Formal Planning Objection – Application 2026/91657

Objection ground: Failure of the original height and separation assumptions; unassessed overlooking, dominance and cumulative loss of residential amenity contrary to Policy LP24

I object to application 2026/91657 because it cannot properly be assessed as an isolated alteration to Plot 23. The Council must assess the complete dwelling as built and proposed—including its altered levels, siting, massing, double garage, veranda and additional window—against the residential amenity of No. 92.

Revision to Plot 23 Garage

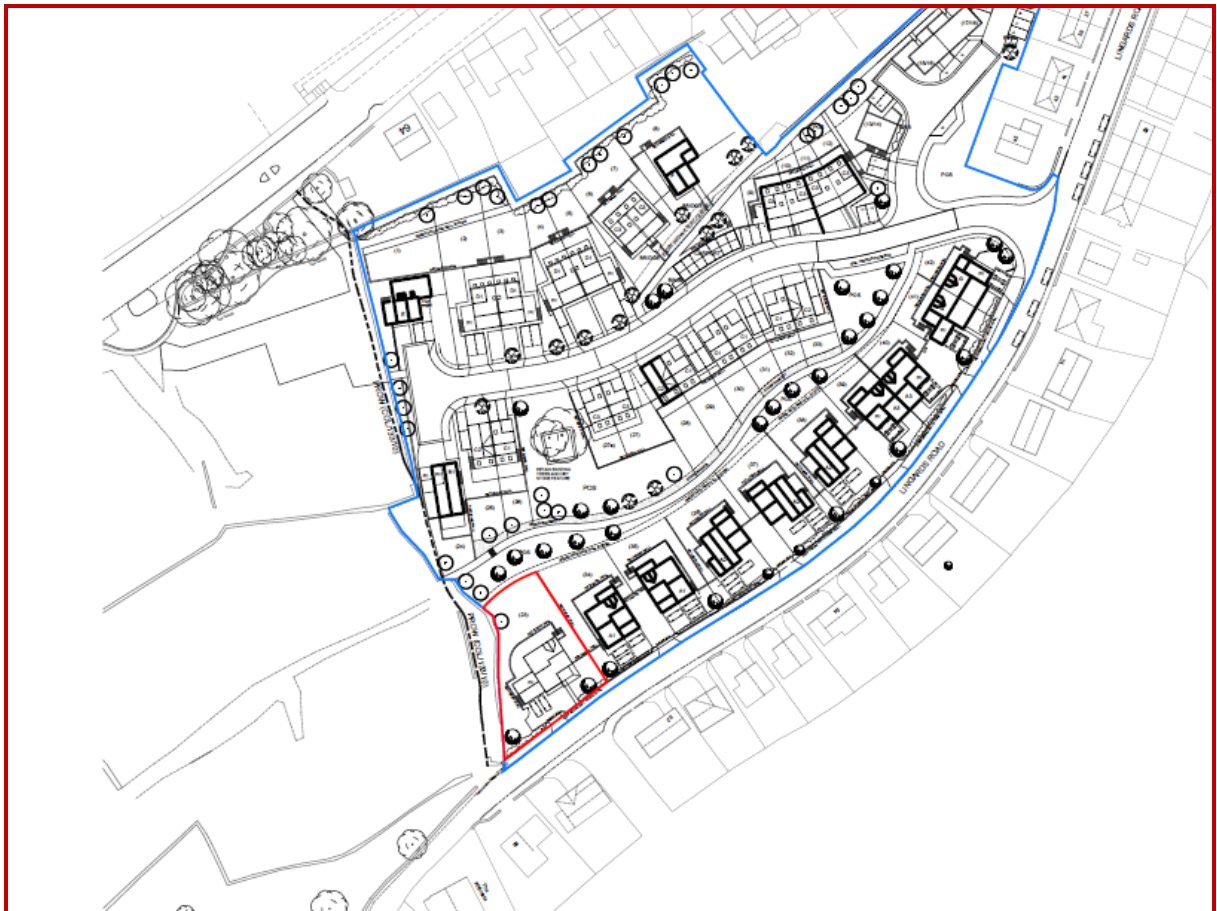
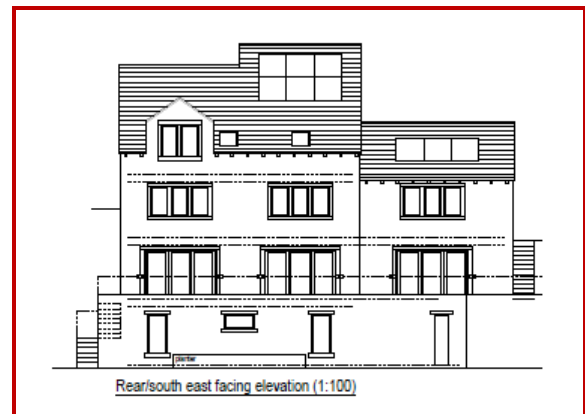
The roof canopy/veranda projects approximately 1.5 metres from the front elevation, bringing an external occupation area closer to No. 92. The supporting material expressly presents it as a place where residents may sit in the morning.

Although the veranda is not a habitable-room window and therefore does not itself engage the 21-metre window-to-window rule, it creates a separate and potentially more intrusive form of overlooking. People using it would be able to stand, sit and remain outside for extended periods from a position elevated above No. 92.

A window has been inserted into the side elevation of Plot 23 which I have not identified on any approved drawing or current application plan.

Because of the increased levels and altered siting of Plot 23, this window appears capable of providing a direct line of sight towards the principal lounge window of No. 92. The Council must establish:

- the approximately 0.82–1 metre level increase;
- the altered siting of the footprint;
- the contradictory building dimensions;
- the enlarged double-garage form;
- the elevated veranda and its intended use;
- the additional side window;
- the loss of the intervening tree; and
- the complete height, massing and visibility of Plot 23 from No. 92.

1. an independently verified topographical survey showing the approved and as-built floor, eaves and ridge levels of Plot 23 and the corresponding levels of No. 92;
2. an accurate survey of the constructed footprint and its position relative to the approved site plan;
3. the actual window-to-window and building-to-building separation distances;
4. scaled sections and sightlines between the principal windows of No. 92 and the windows and veranda of Plot 23;
5. an assessment of standing and seated views from the veranda;
6. a determination of the planning status and overlooking effect of the side window; and
7. a reasoned comparison with the Manchester Road assessment, explaining why any separation below the Council's own 32-metre comparator provides equivalent protection despite the absence of its mitigating features.
